Listed Building Consent for Alterations, Extension or Demolition of a Listed Building

Development: Listed building consent for repair works to timber windows, masonry, dormer, leadwork and outbuilding chimney, with minor internal alterations.
Location: 18 Bond Street Arundel BN18 9BL

Job Title	18 Bond Street, Arundel		
Client	Ms. J. Webb		
Drawing Name	Elevations - Existing		
Drawing Status	Planning		
Drawn by	ALP	Date	June 26
Checked by	LW	Date	June 26
Drawing Scale	1:100 at A3		
Drawing No	260012/ 02		Revision A

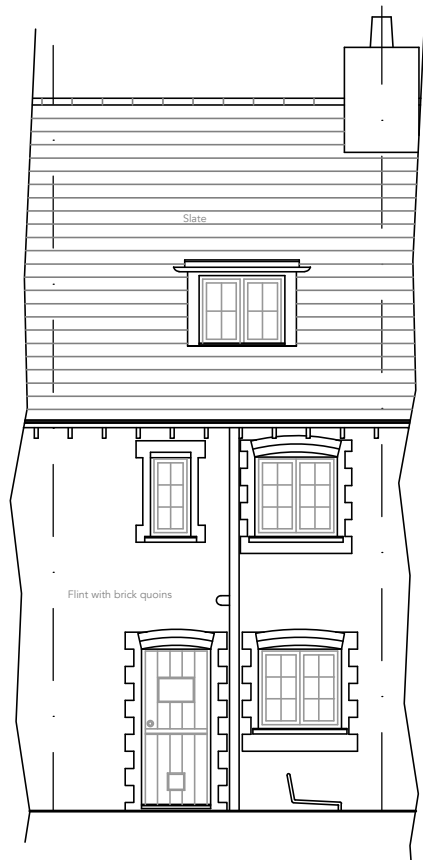
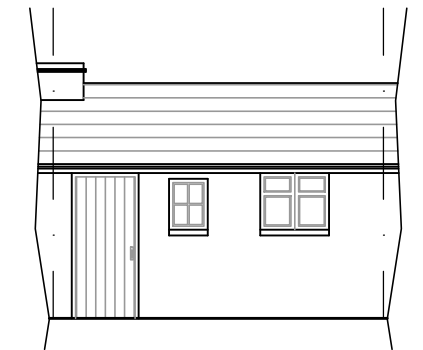
The porch roof is inconsistent between the elevations and plans. Please review and amend.

South Elevation (Outhouse)

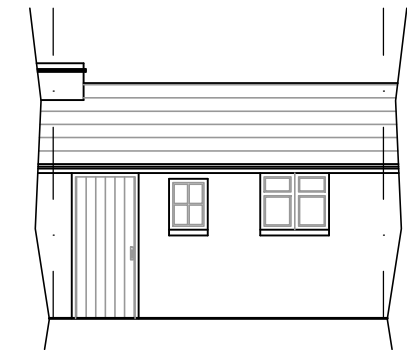
Elevation plans are required for the store at the rear of the house due to works being proposed there.
